Our Ref: 18188

21 June 2018

**RE: CRANBROOK SCHOOL REDEVELOPMENT SSD
REVIEW OF ENVIRONMENTAL IMPACT ASSESSMENT
TRAFFIC AND PARKING ASPECTS**

DRAWING TITLE:
Traffic Management
Kiss & Drop

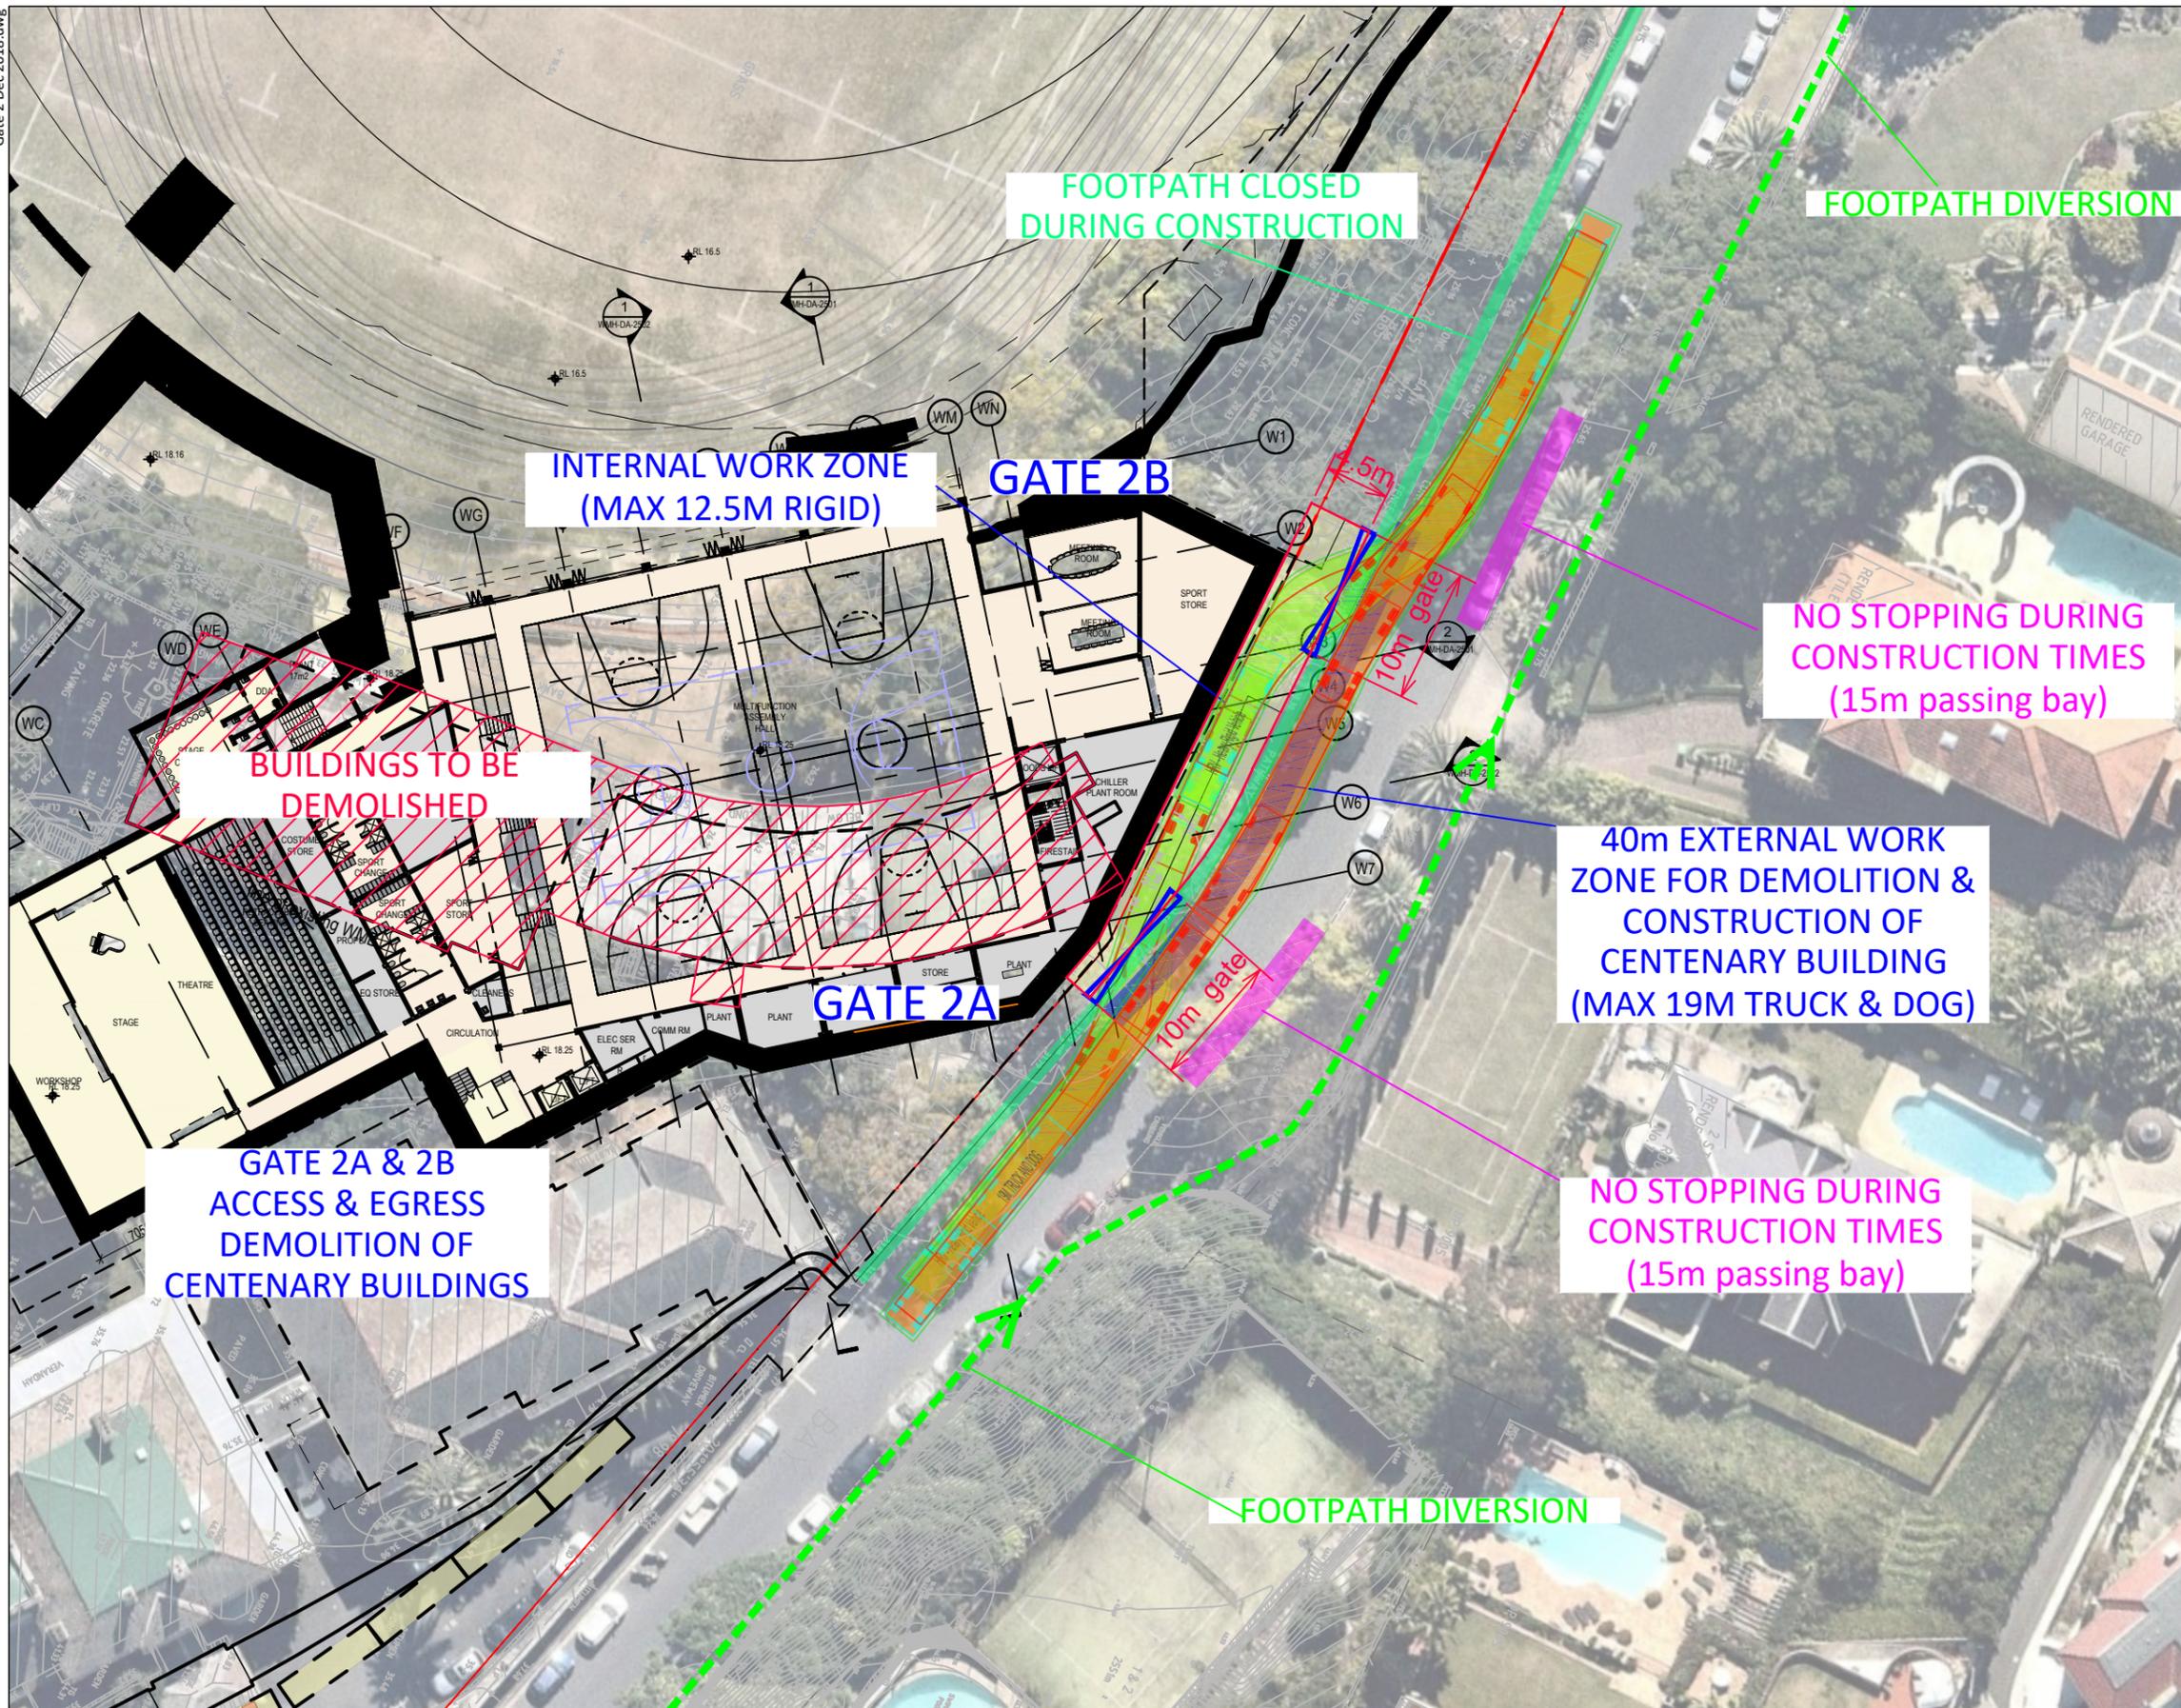
The proposed drop off / pick up facility within the School would only provide 18 car spaces which would effectively replace the existing on street drop off / pick up facility on Rose Bay Avenue. Thus the existing Victoria Road drop off / pick up activity is unlikely to be accommodated by the new facility.

The Traffic Report has assumed that existing dwell time for the pick up can be reduced from 5½ minutes to 2 minutes with the implementation of a "head of queue" operation. Based on TTPP's experience with surveys of the Trinity Grammar School on site drop off / pick up facility

With the surveyed demand for the drop off / pick up the proposed provision of 19 spaces would appear to be inadequate to accommodate all vehicles queued within the site.

However, if applied to Cranbrook's drop off / pick up facility with a storage length of 110 metres then vehicle queues could be expected to extend well out onto Victoria Road.

Given the very real potential for extensive vehicle queuing it is considered that further details regarding the operation and capacity of the drop off / pick up facility need to be provided before an adequate assessment of the implications can be made.

As shown in Figure 2, the storage area between the Rose Bay Avenue roadway and the head of queue for vehicles having dropped off or picked up a passenger is only 1-2 vehicles.

As such any vehicle queuing at the exit driveway will adversely impact the ability of vehicles to move through the drop off / pick up facility, thus exacerbating queues onto Victoria Road.

Furthermore the alignment of the internal road as it approaches the Rose Bay Avenue gate creates a very acute angle such that vehicles will not be near perpendicular with the footpath crossing and road as prescribed by AS2890.1 thus making drivers look around and over their shoulder to see approaching pedestrians and vehicles in an undesirable manner.

Thus for operational and safety reasons, if the proposed drop off /pick up is approved then it recommended that vehicle movements out of the exit be restricted to **LEFT TURN OUT ONLY**.
